**Subject:** 2025/93514 at location land at, Brownhill Farm, Old Lane, Birkenshaw, BD11 2JL

Please see ecological commentary below:

Existing Plan 1: 200

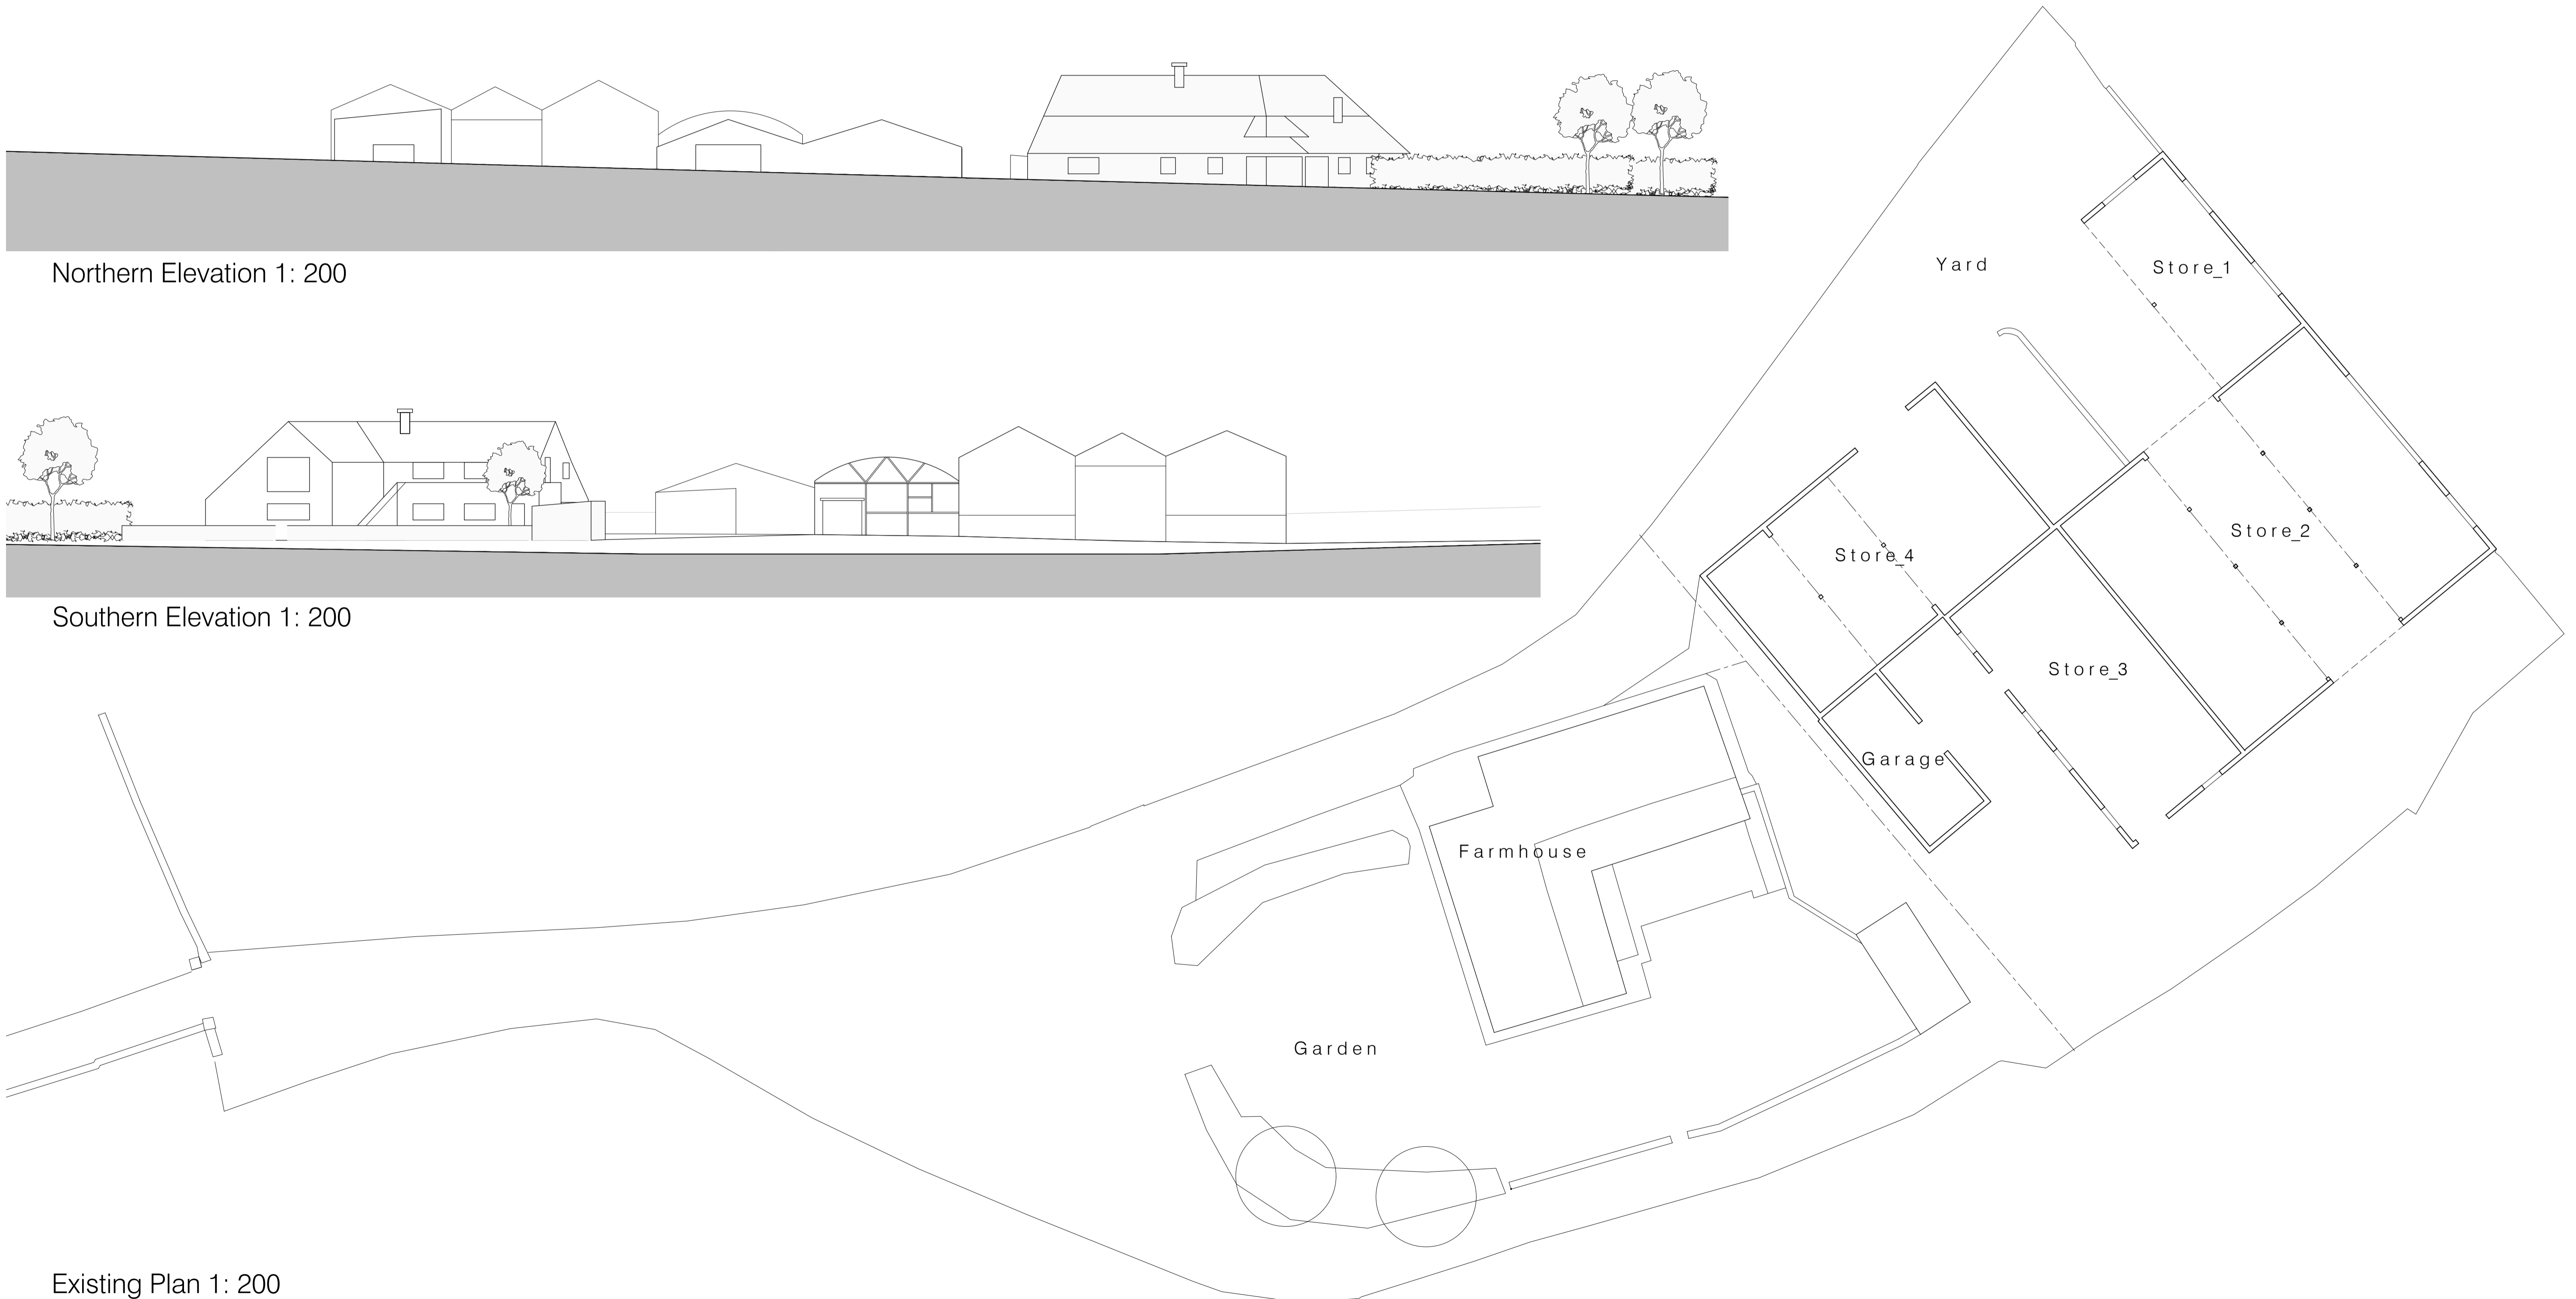
- There are not details assessment notes of the buildings to justify mentioning that none of them has suitability for roosting bats. Further details / descriptions are needed as there is simply not enough to justify the permitting of demolishing buildings
- Other – *“There is no habitat on-Site or within influencing distance to support this species.”* This is provided for a few parts in the report where certain species are addressed. They should be saying the type of suitable habitat that is absent.
- A lot of the references for best practice guidance mentioned in pages 17-19 are out of date.
- For BNG – Further details on methodology, how the mitigation hierarchy was addressed; and post intervention plans are required for a complete metric.

Unfortunately, I cannot accept this report in its current state. Should these matters be addressed prior to decision then it can be reviewed again.
